Planning Reference BR/288/17/PL

Rear extension to storage & workshop areas. Main Unit, rear of Holmlea, Town Cross Avenue,
Bognor Regis.
Applicant CW Bikes.

Proposed North Elevation

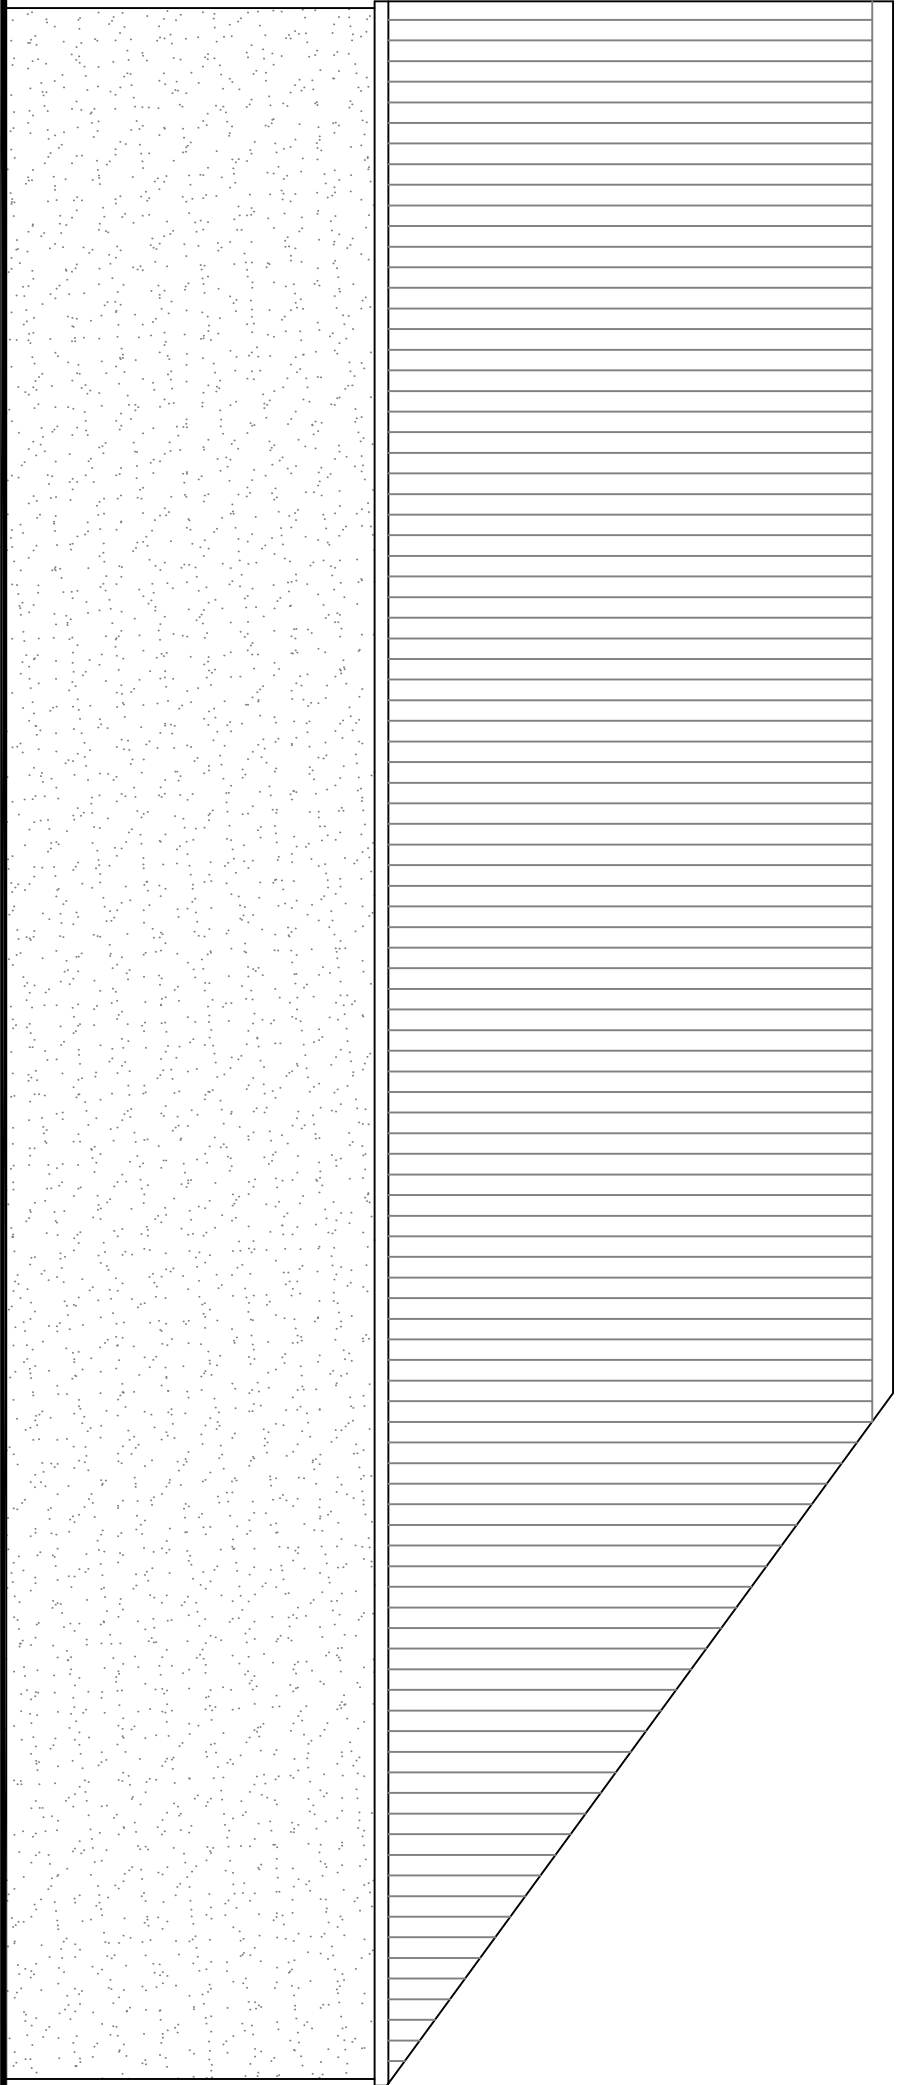
Looking at the proposed plans, the upper floor windows will look directly onto the back gardens of Essex Road residents and we are concerned that our right to privacy will be compromised. We are naturists and sunbathe naked, in an area of the garden which is closer to the house and therefore concealed from the view of immediate neighbours. However we are concerned that the upper windows of the building will enable those inside to look directly into this area of the garden and we will lose this privacy.
